**From:** Paul Lavery [REDACTED]  
**Sent:** 22 November 2019 18:16  
**To:** Anita Gardner <[Anita.Gardner@arun.gov.uk](mailto:Anita.Gardner@arun.gov.uk)>  
**Cc:** Tom Wilson [REDACTED] Alan Werrett  
[REDACTED] Nina Vogric <[REDACTED]>  
**Subject:** Fwd: Pound Place - Report ref R18-12844

We have been forwarded your email by Shivani and I have spoken with Sarah Burrow (Engineering Assistant) who drafted the request for clarification and/or further information regarding Pound Place (Planning Consultation ref A/161/19/DOC). Our response follows the same order as per her comments (email dated 20/11/19):

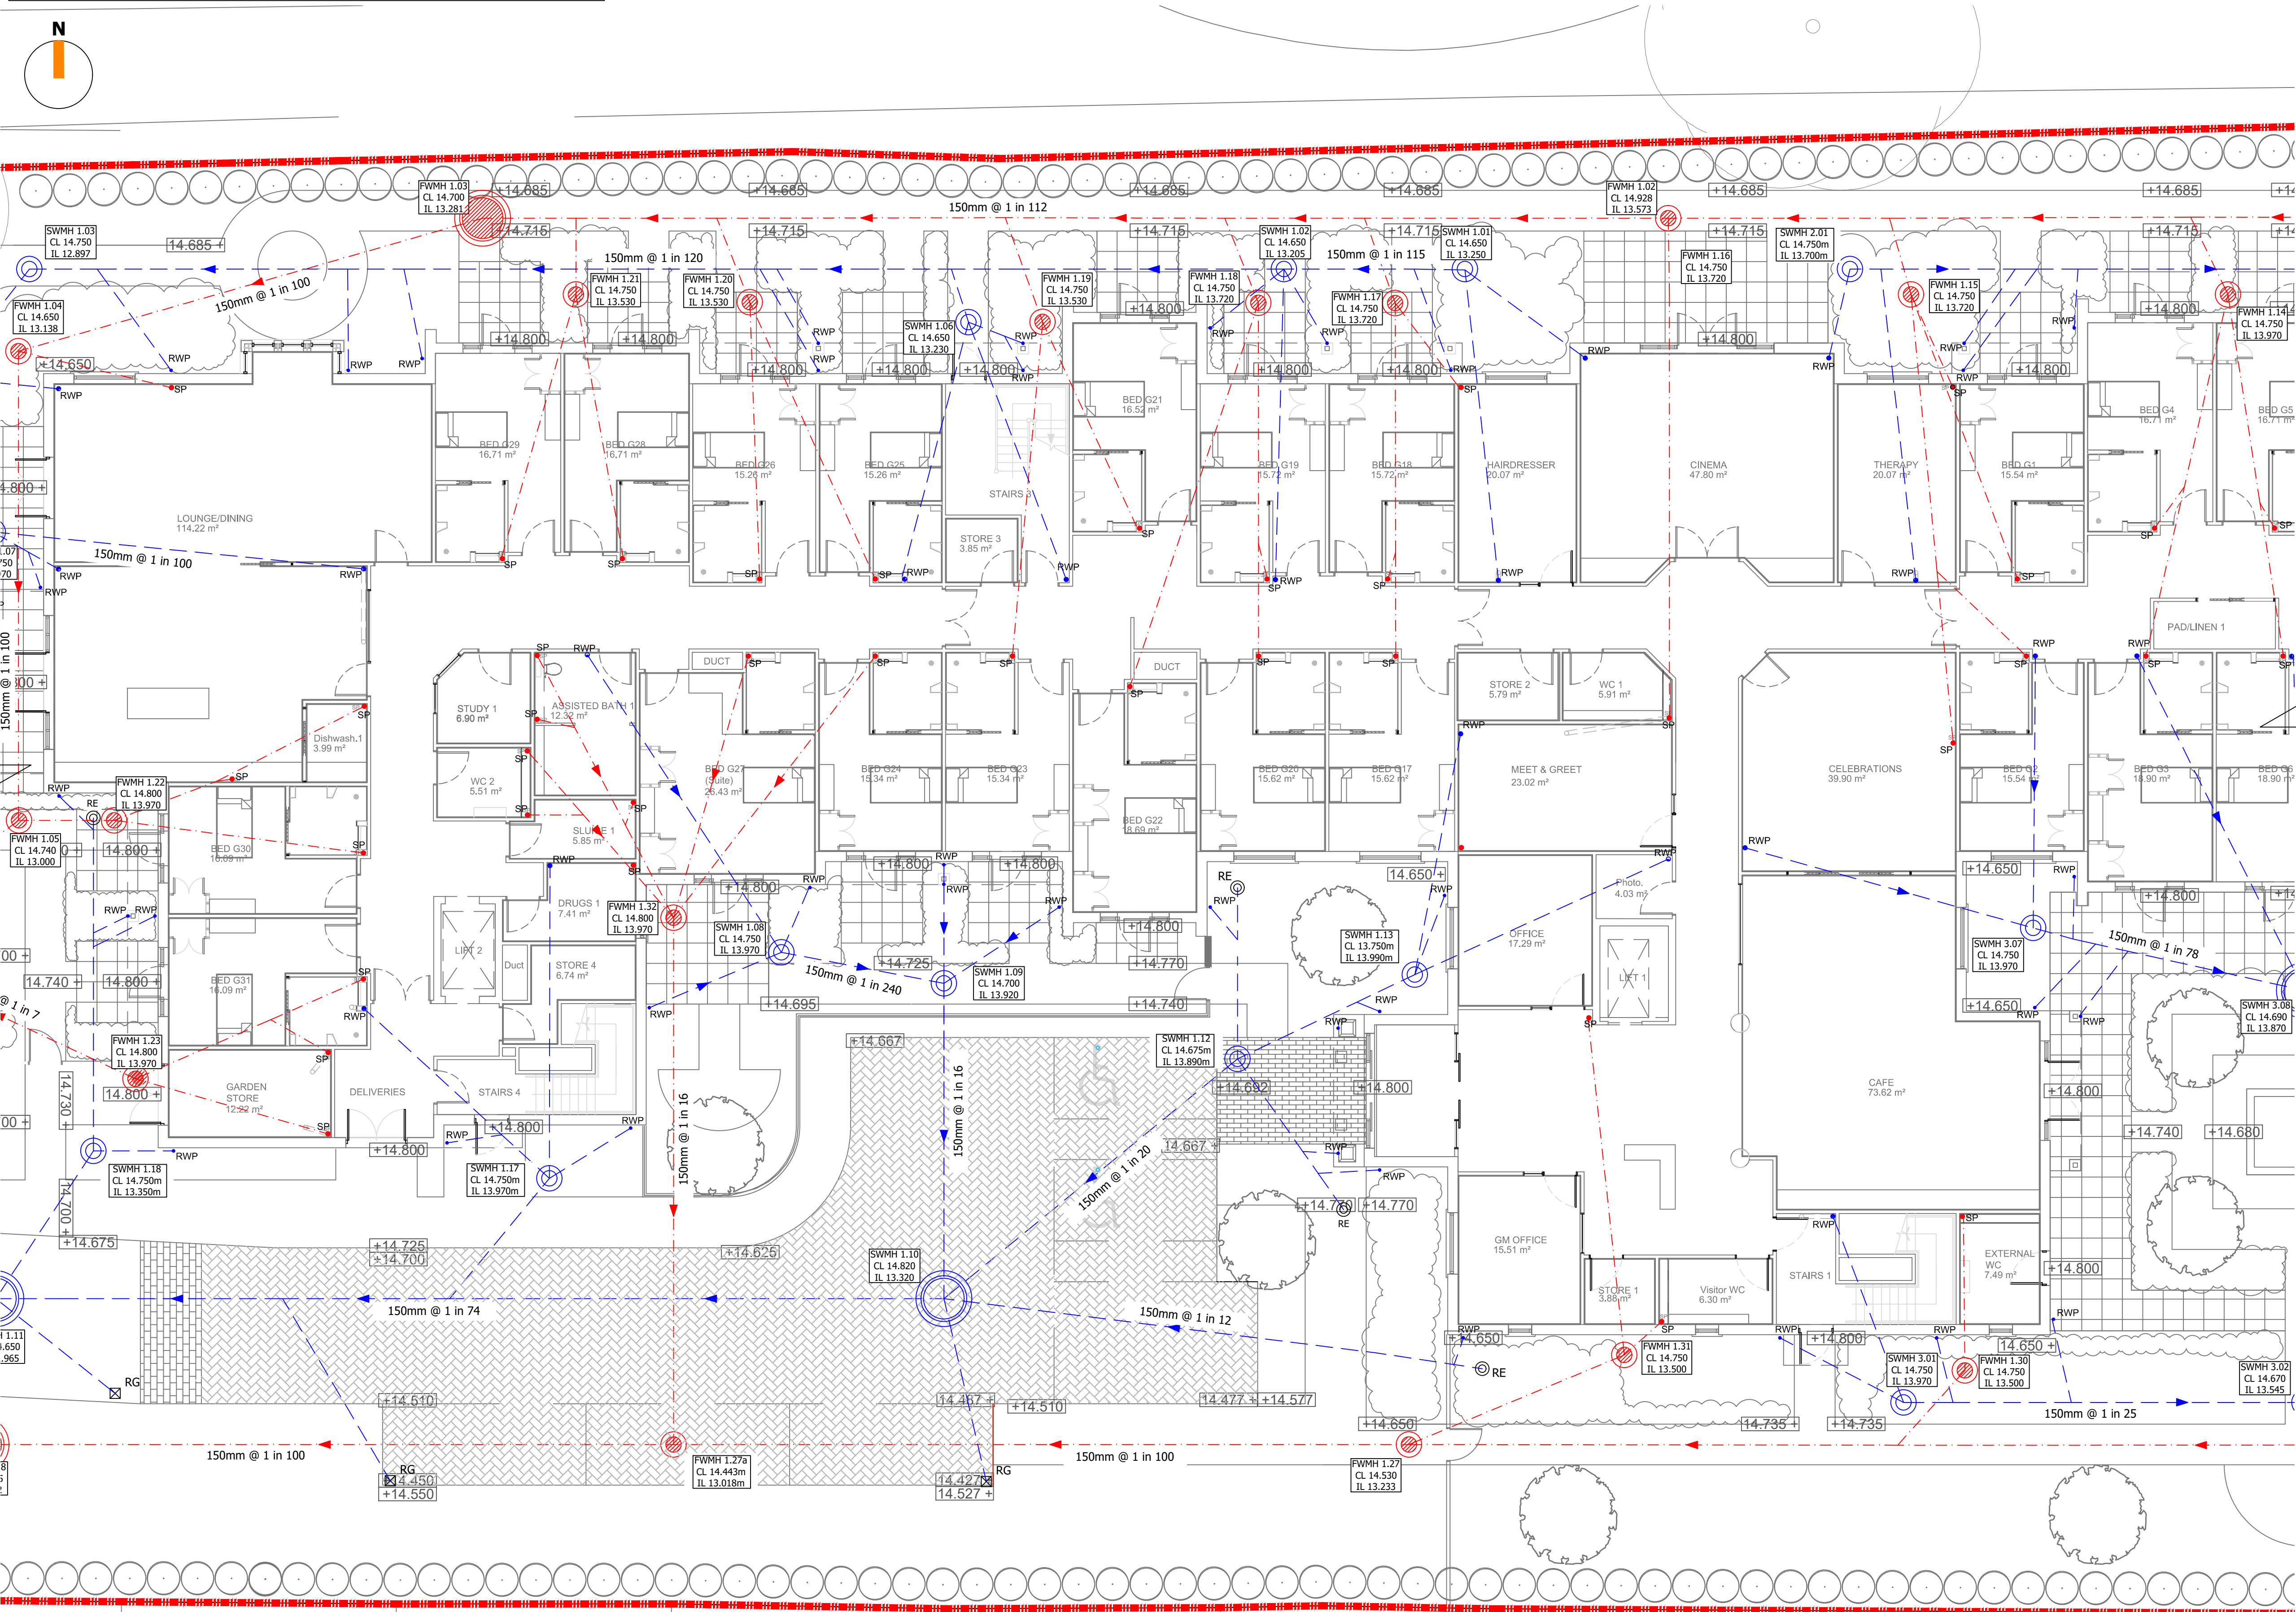
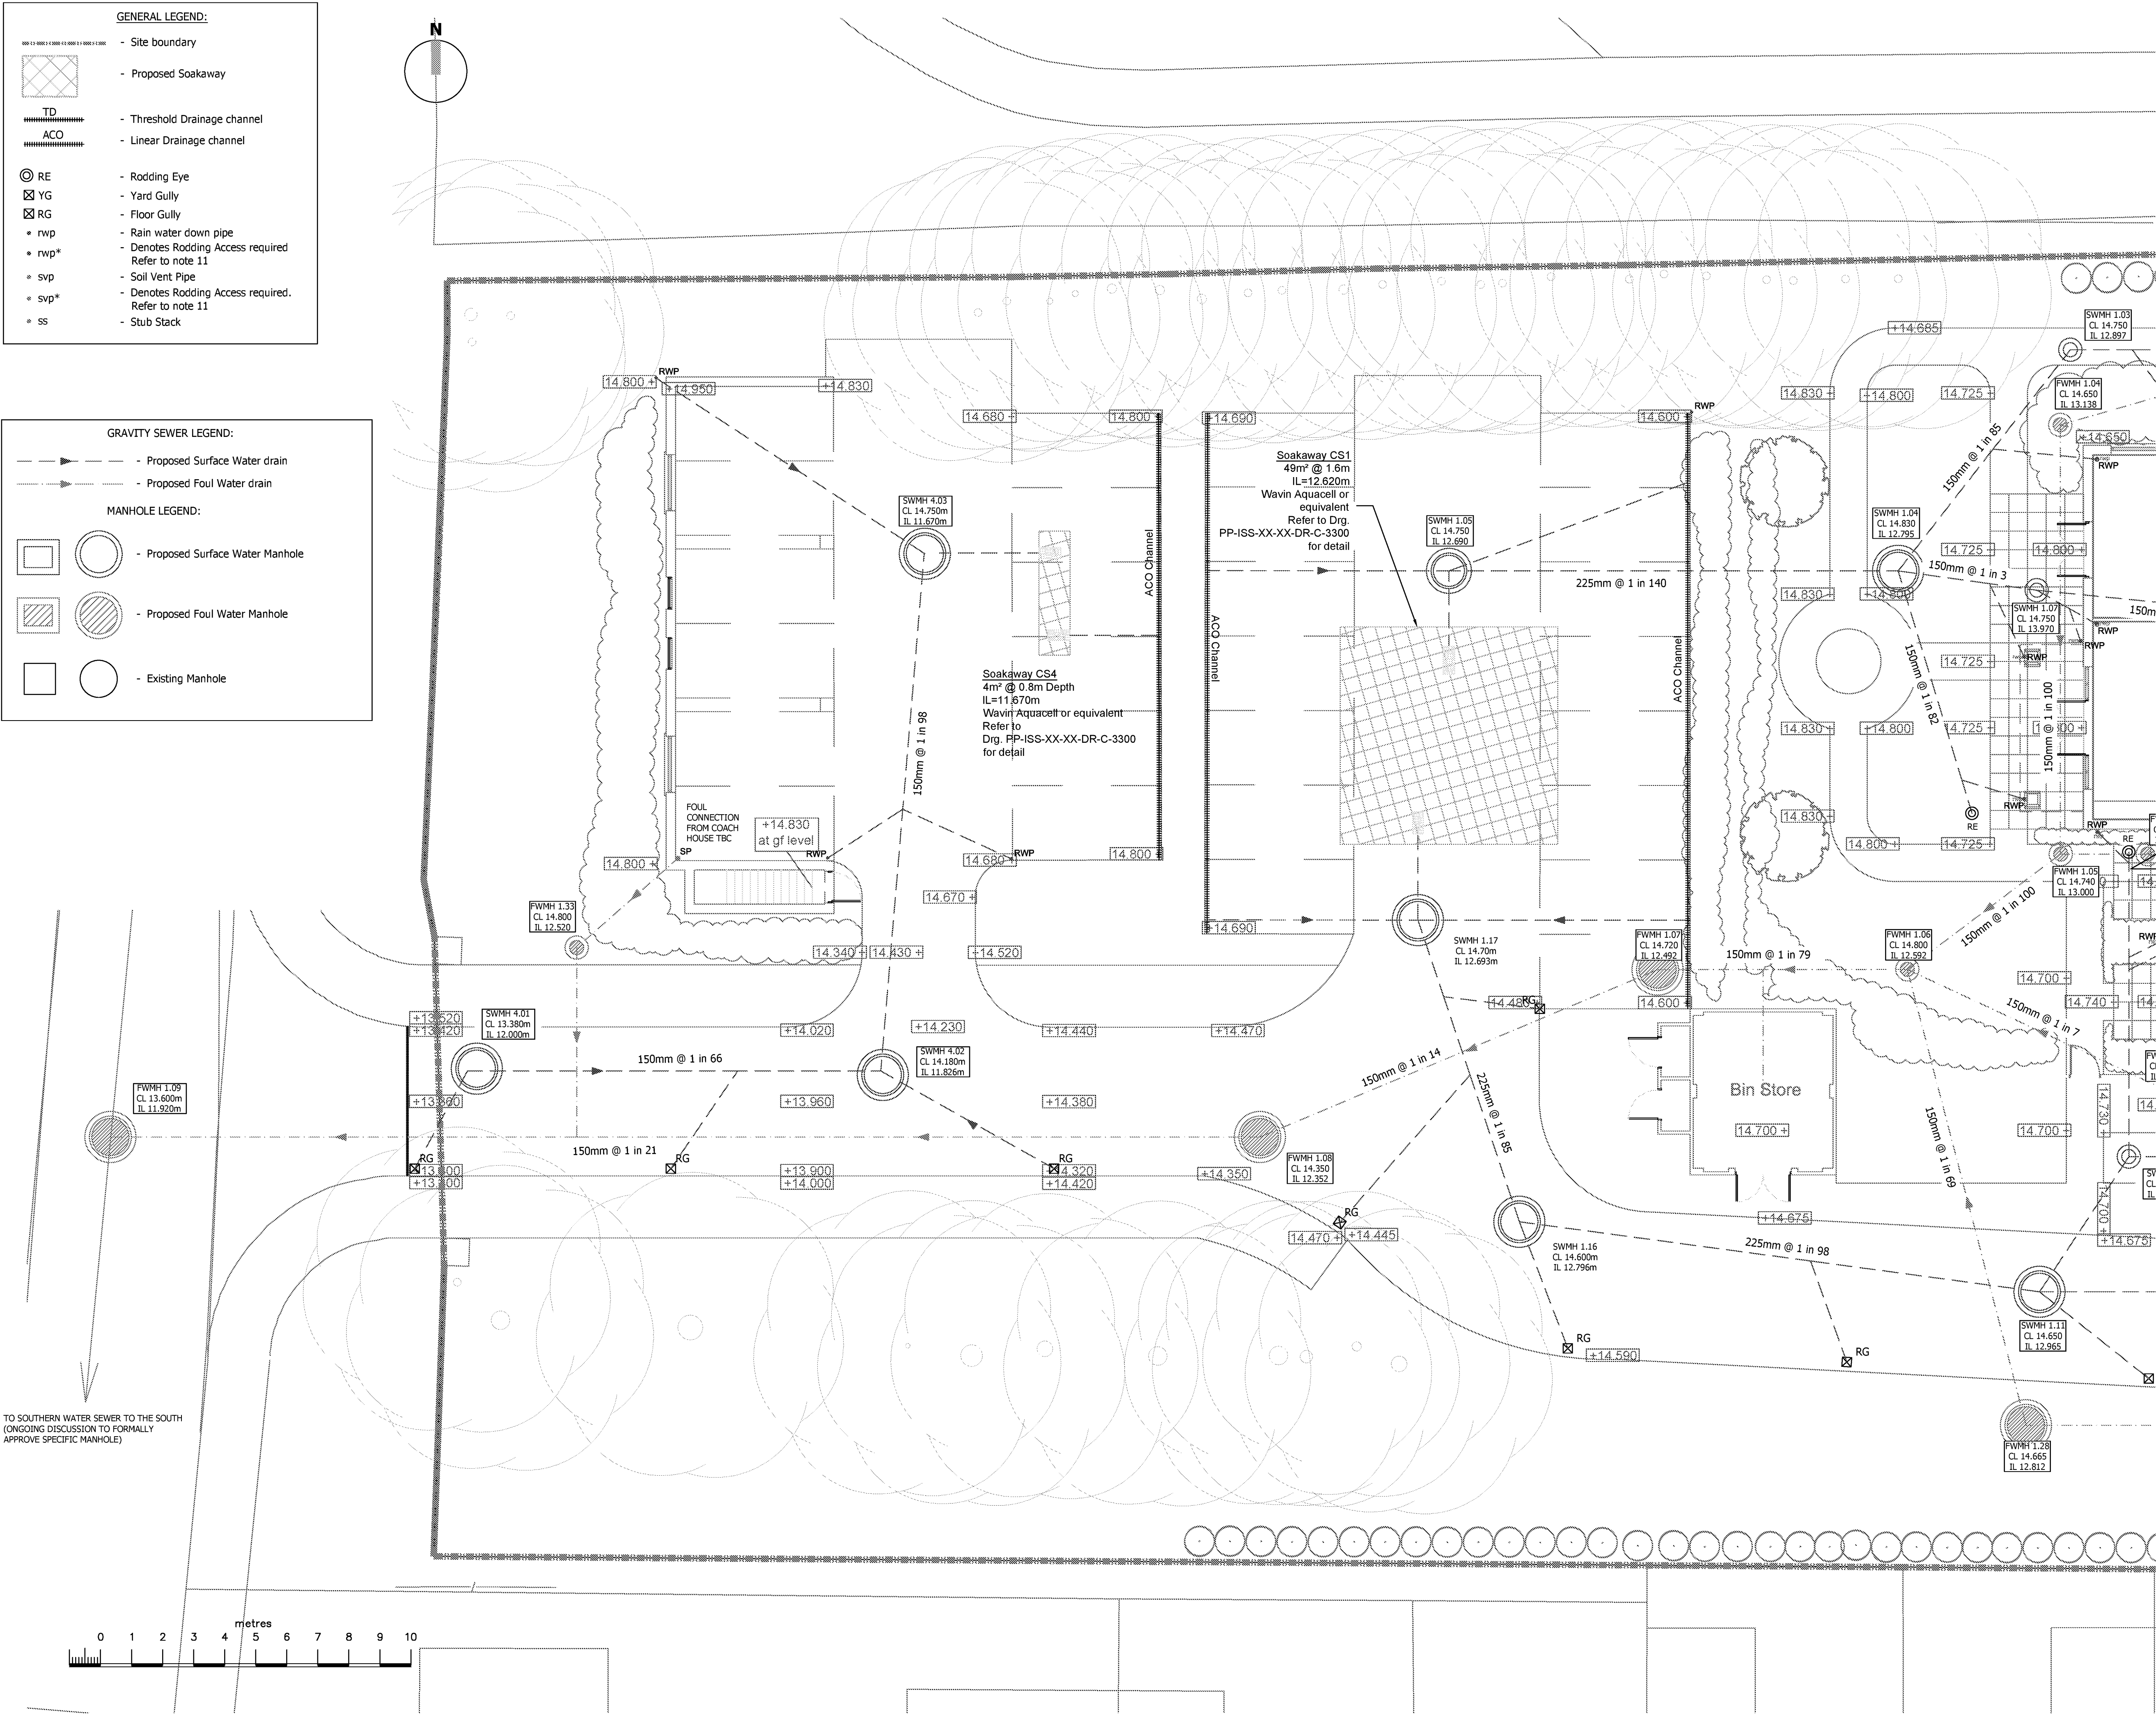
2 - Our design is based on the infiltration rates used by ARC Engineers stated in their modelling results for their soakaways located at approximately the same depth as our design. Sarah has expressed concern that the rates used are based on the 6m boreholes and not the shallower test pits. We have calculated the infiltration rates for the test pits that correspond with our infiltration devices and the infiltration rates are very good, therefore the changes to the soakaway devices are expected to be minor. We are currently updating our model to ensure everything is fully coordinated and issue our drainage plan, calculations and report using the revised rates on Monday.

3 - The permeable paving mentioned in the DDSR (Section 6.3) was removed during the design development. Sarah has expressed concerns if water quality still can be achieved with the removal of this SuDS tool. The Client has agreed to introduce permeable paving to the parking bays to the west, providing the requested water quality treatment for the western road and parking areas surface water runoff. As noted above we are updating the model and will issue Monday.
